RE: Fill Permit Application, 80 Farragut Street  
(#2004-0001) (CBL 339J021)

On January 30, 2004, the Portland Planning Authority granted approval for a fill permit at #80 Farragut Street with the following conditions:

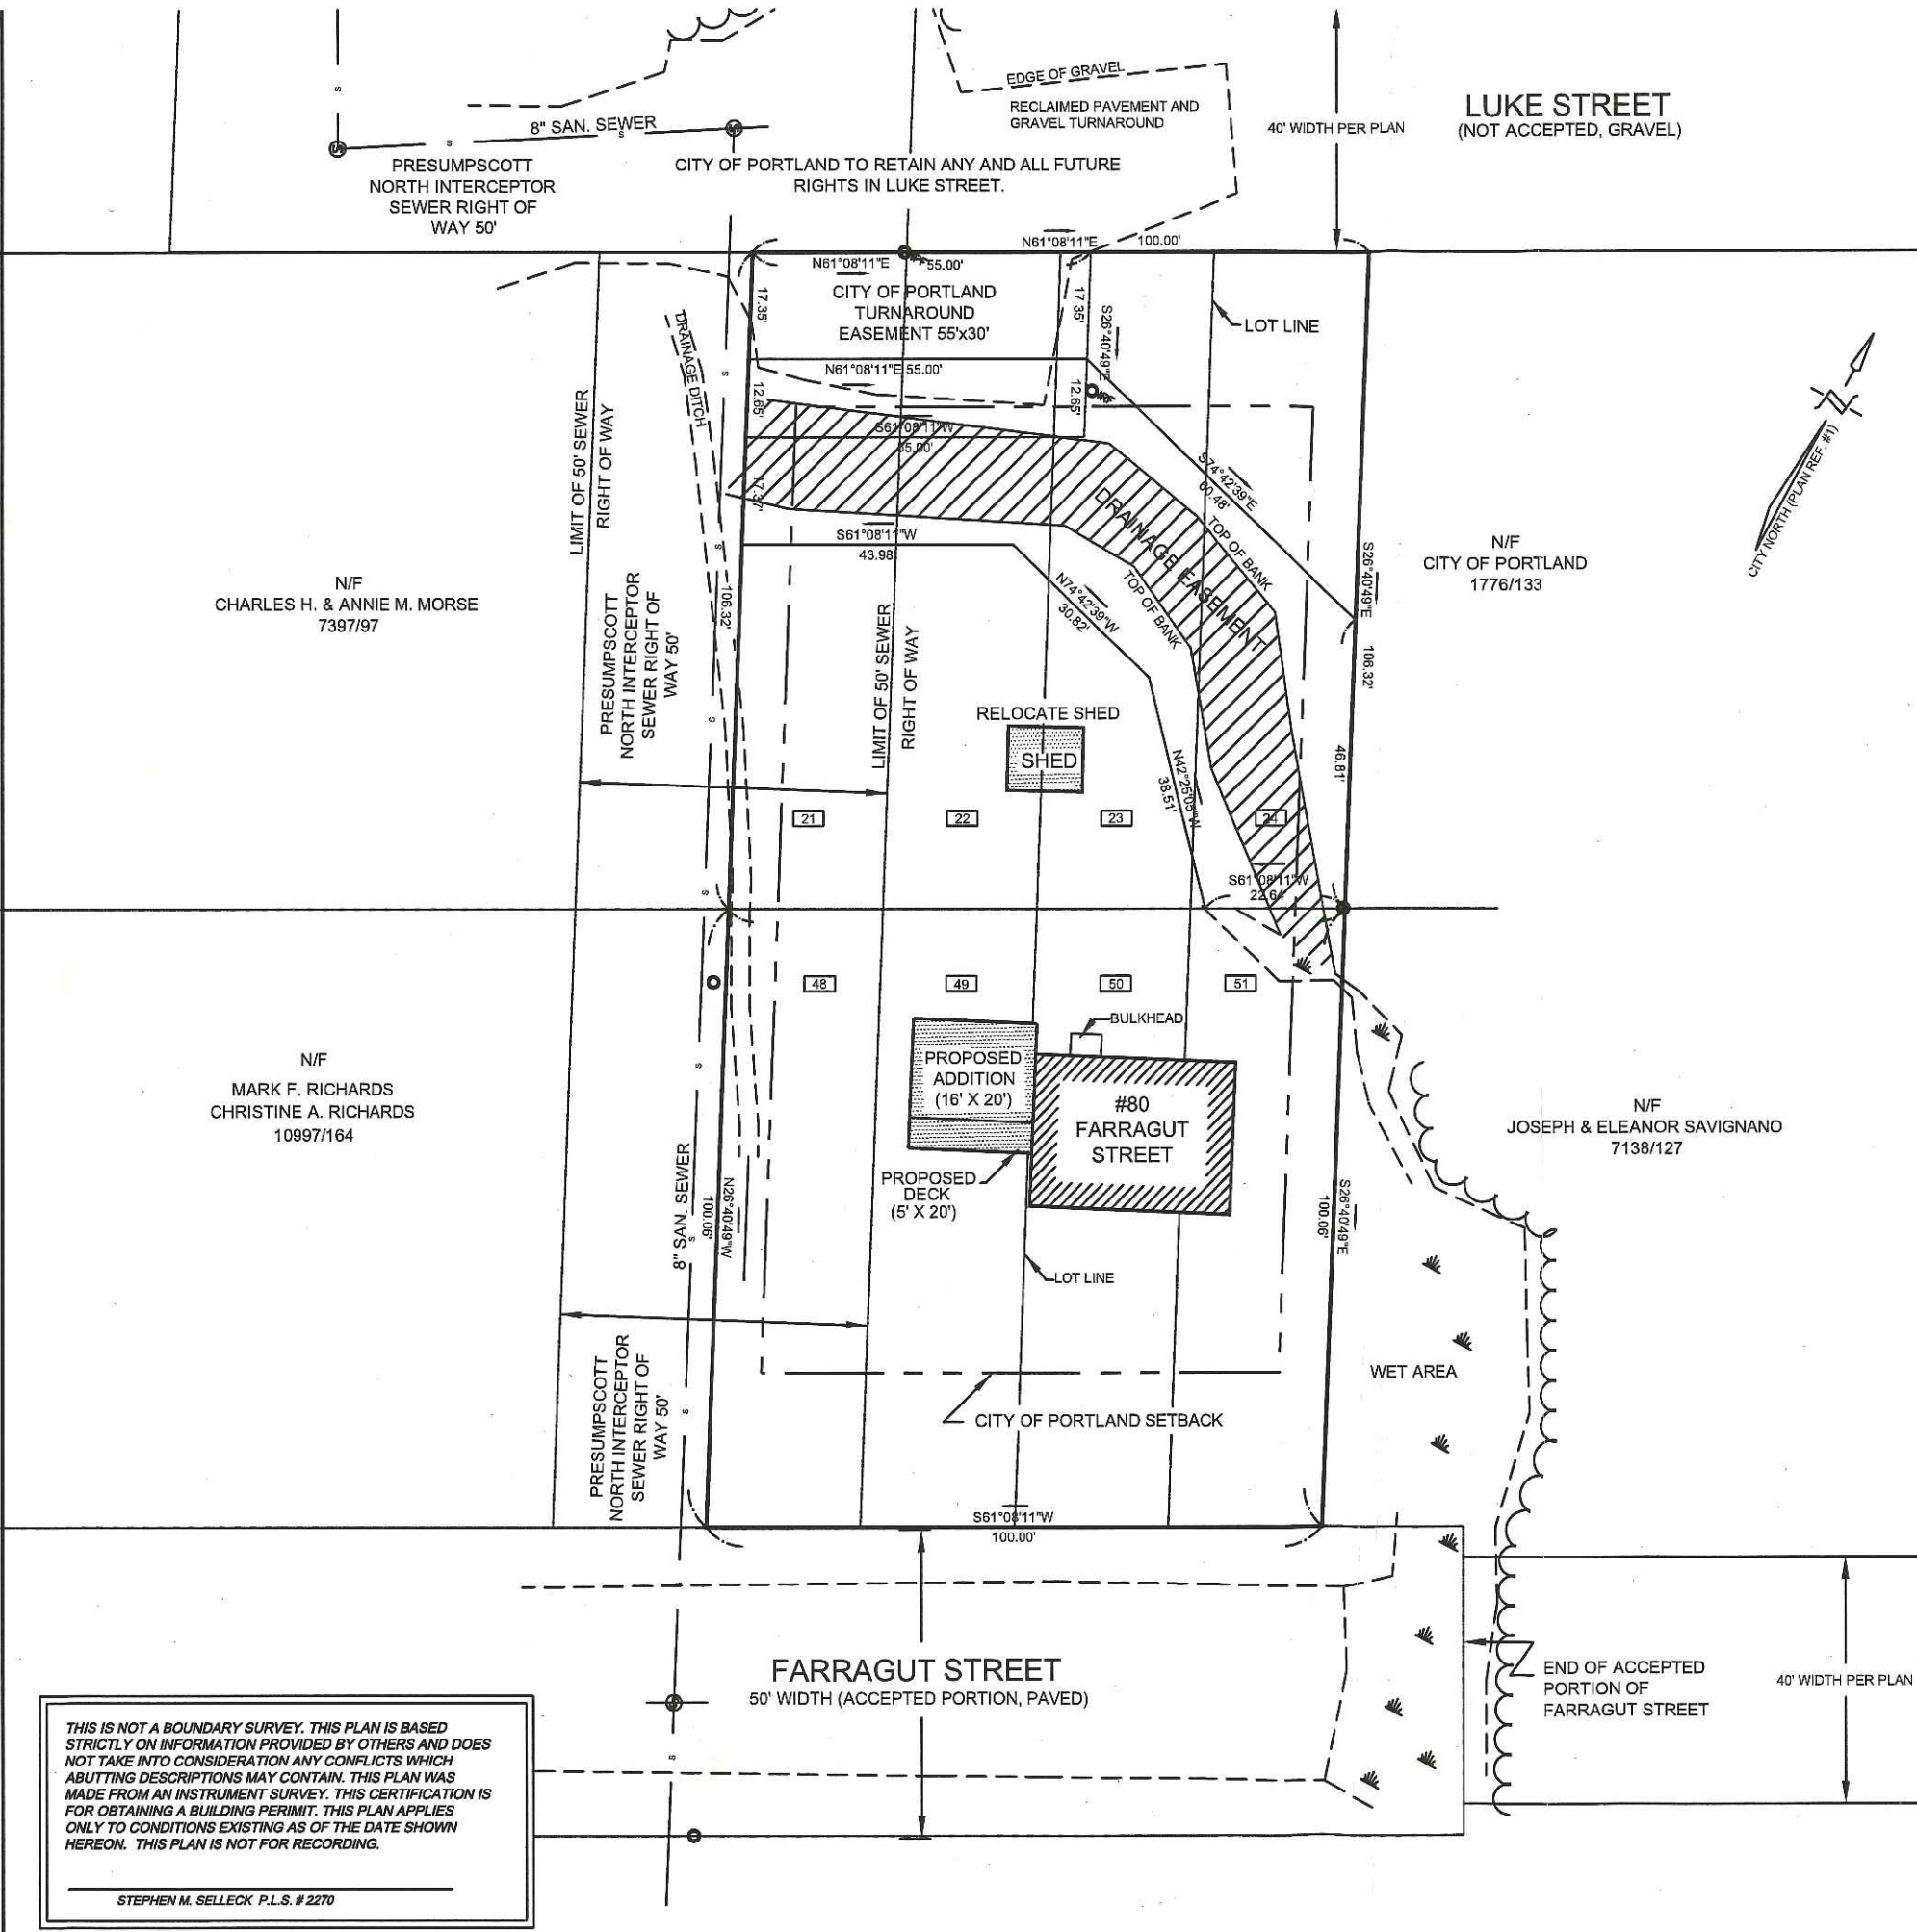
1. *Prior to soil disturbance, erosion control measures shall be installed using best management practices.*
2. *A copy of the deed containing a written description of the easement shall be submitted to the City.*
3. *The swale shall maintain a positive slope in order to convey any sheet runoff it may collect.*
